STATE OF NORTH CAROLINA
DEPARTMENT OF TRANSPORTATION

April 26, 2021

Subject: **Application for Section 404 Nationwide Permit 14, and 401 Water Quality Certification** for the proposed replacement of Bridge 132 on NC 73 over Dutch Buffalo Creek in Cabarrus County, NCDOT Division 10.
TIP B-5813. Debit \$570 from WBS 45767.1.1

This revised application address four primary concerns that resulted in the return of the previous application.

CHANNEL CHANGE CONSTRUCTION SEQUENCE STA. 20+00 -L-

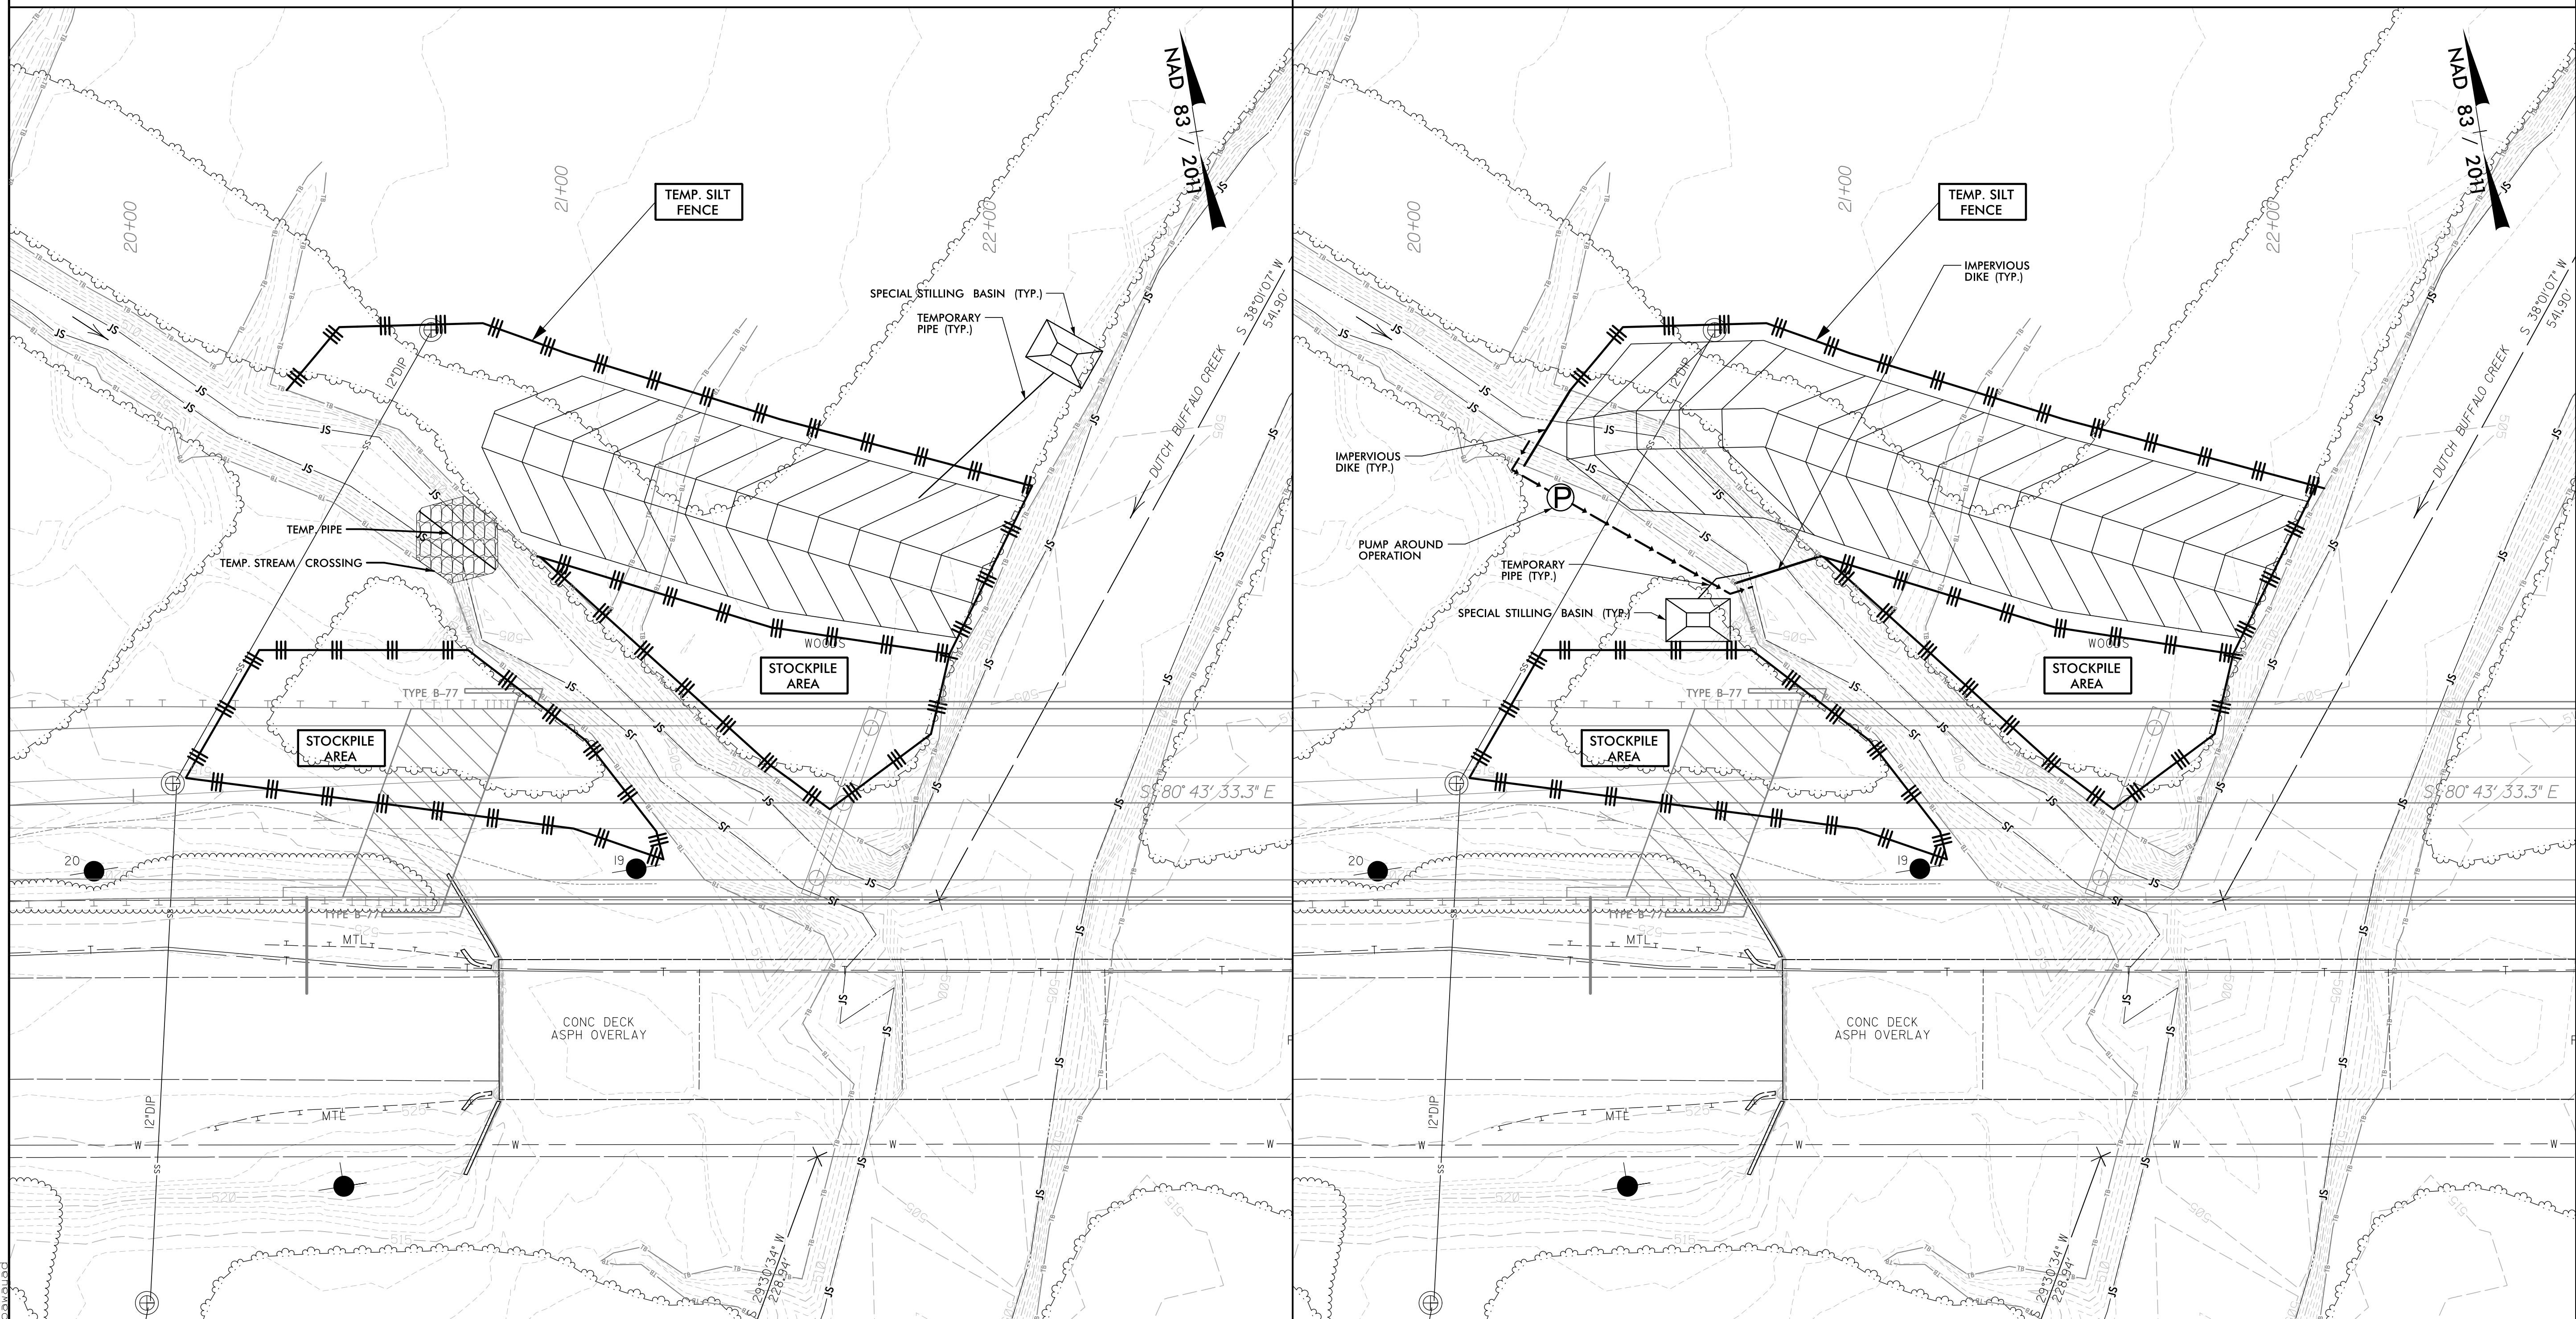
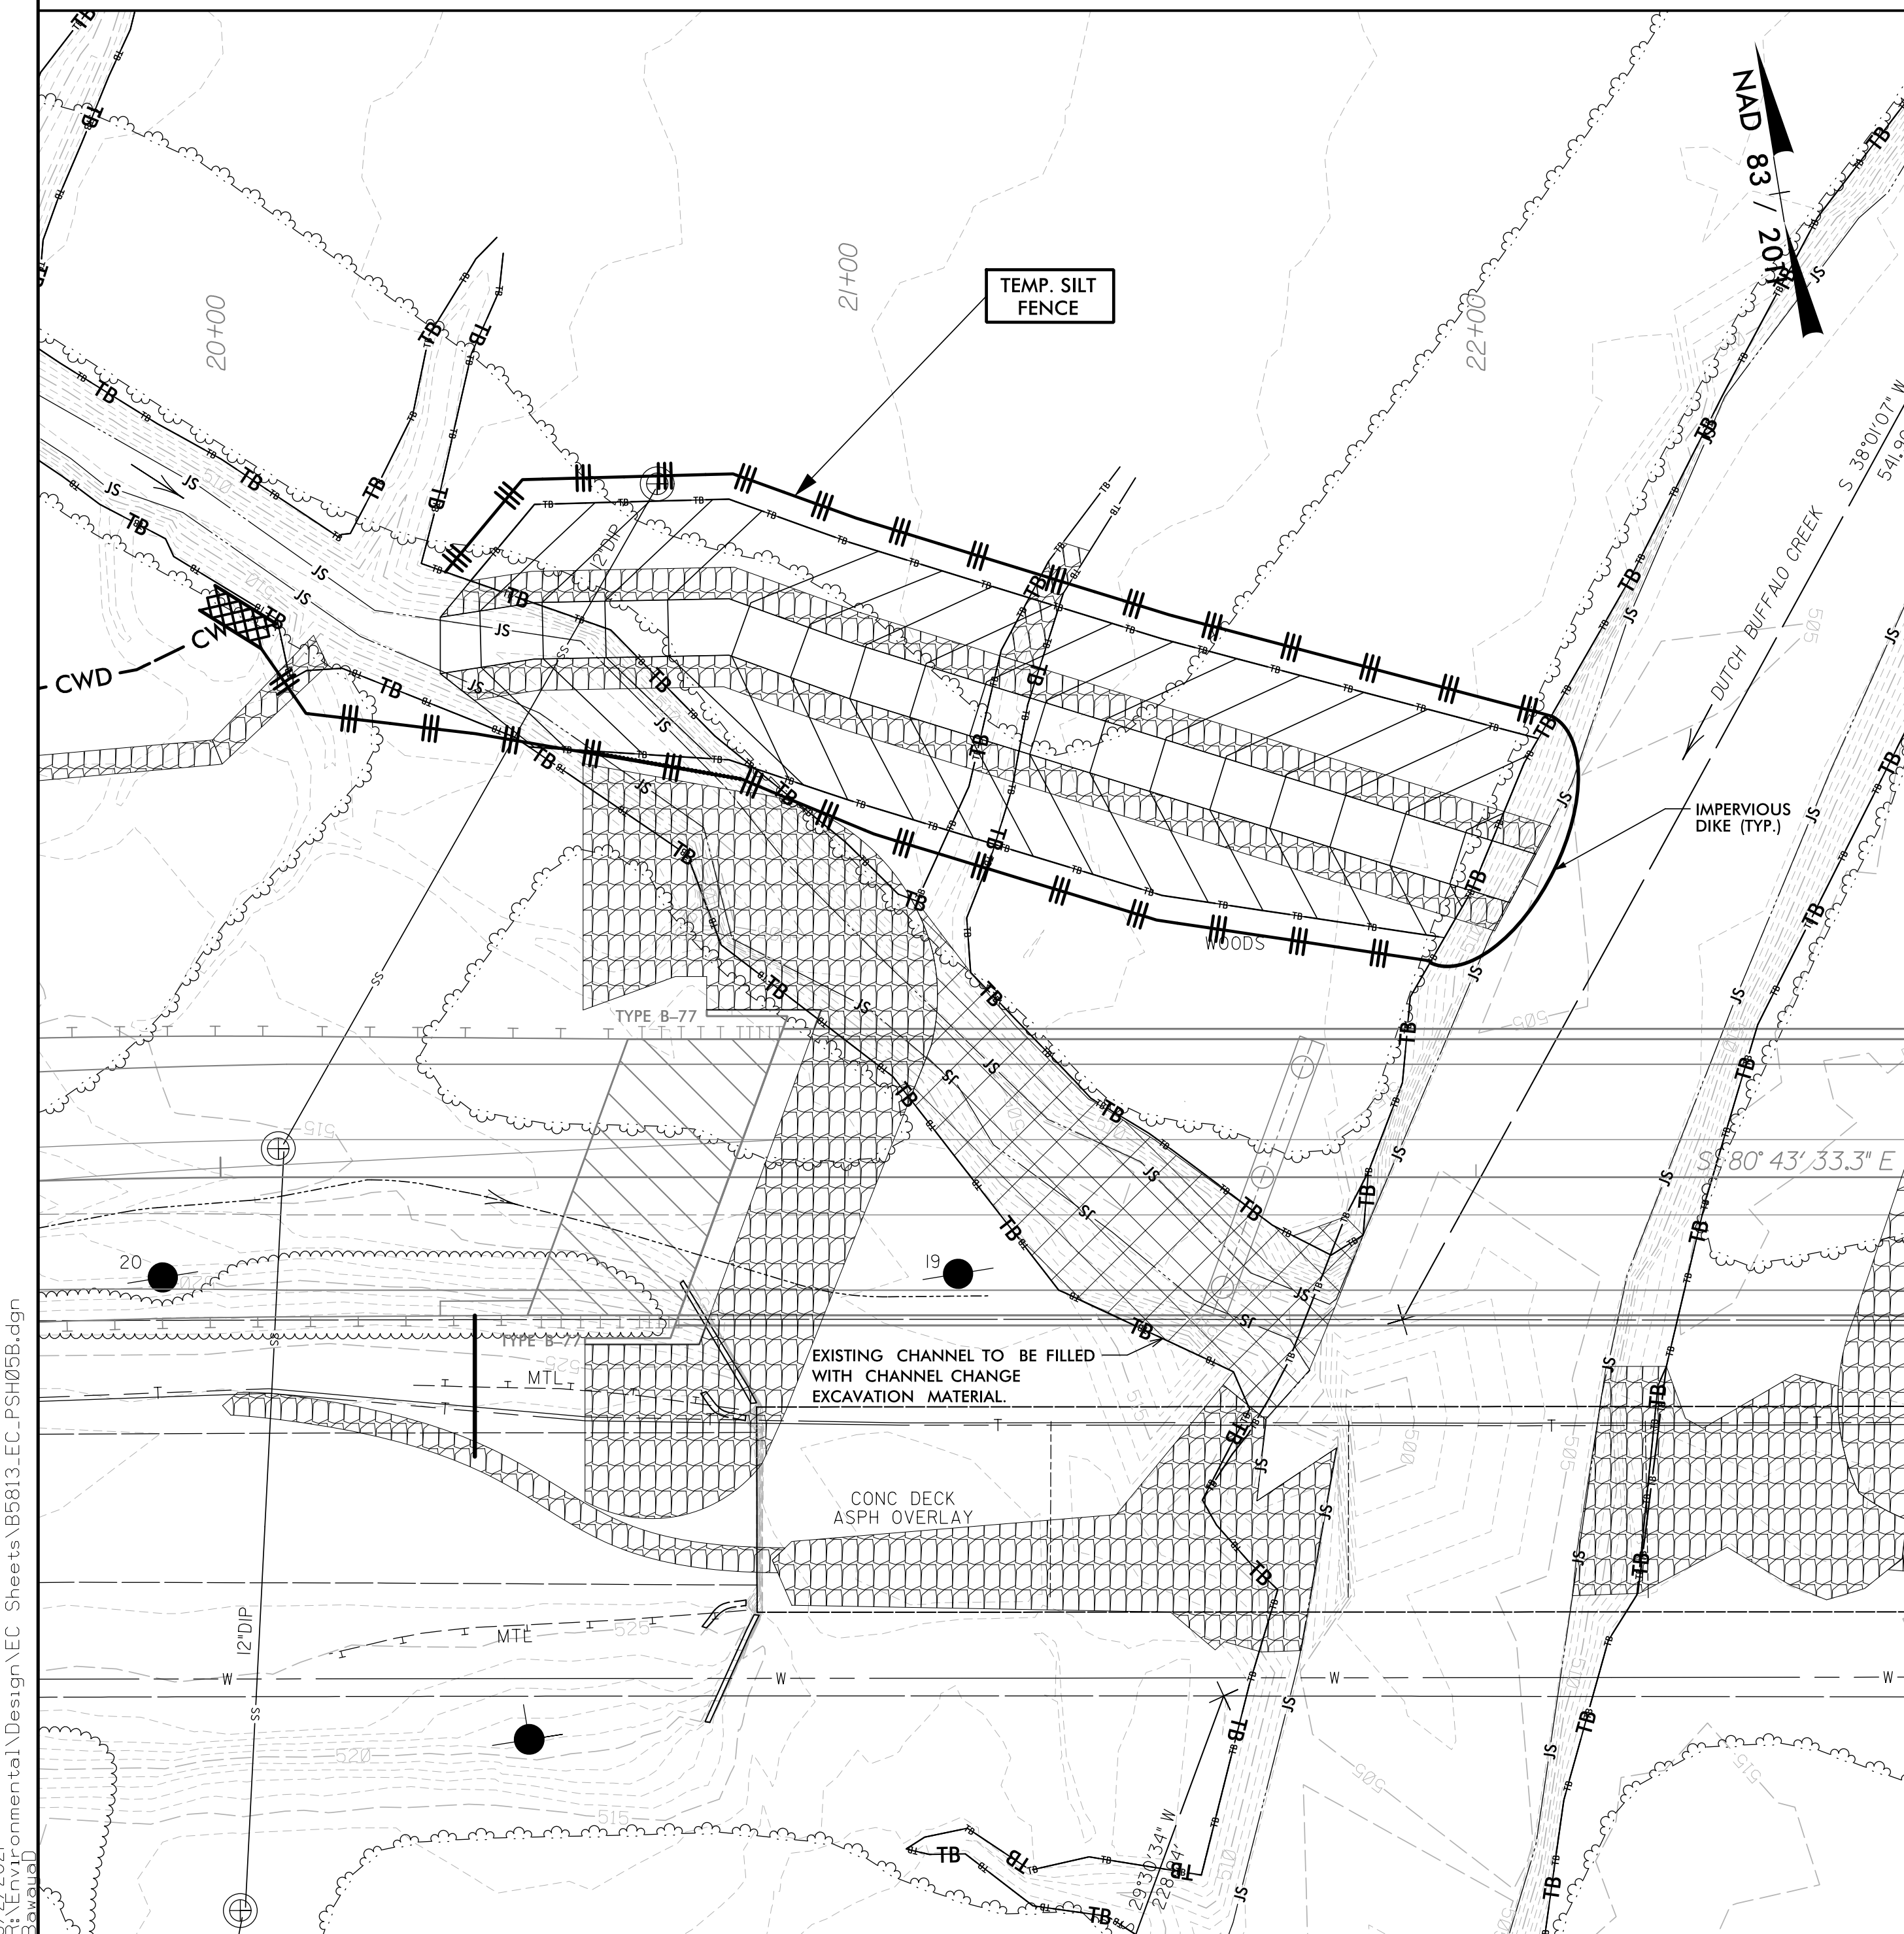
Concern 1: A UT draining from the adjacent field is jurisdictional and the impacts should be accounted for.

Concern 2: An unstable non-jurisdictional drainage from the adjacent field should be stabilized to prevent sediment discharge into the stream.

The impacts for this stream are now accounted for on the permit drawings. Furthermore, the stream relocation portion of the project will start further downstream, so the previous permanent impacts to this system have been minimized to temporary impacts.

Riprap has been added to ensure this system transitions into the relocated channel in a stable manner.
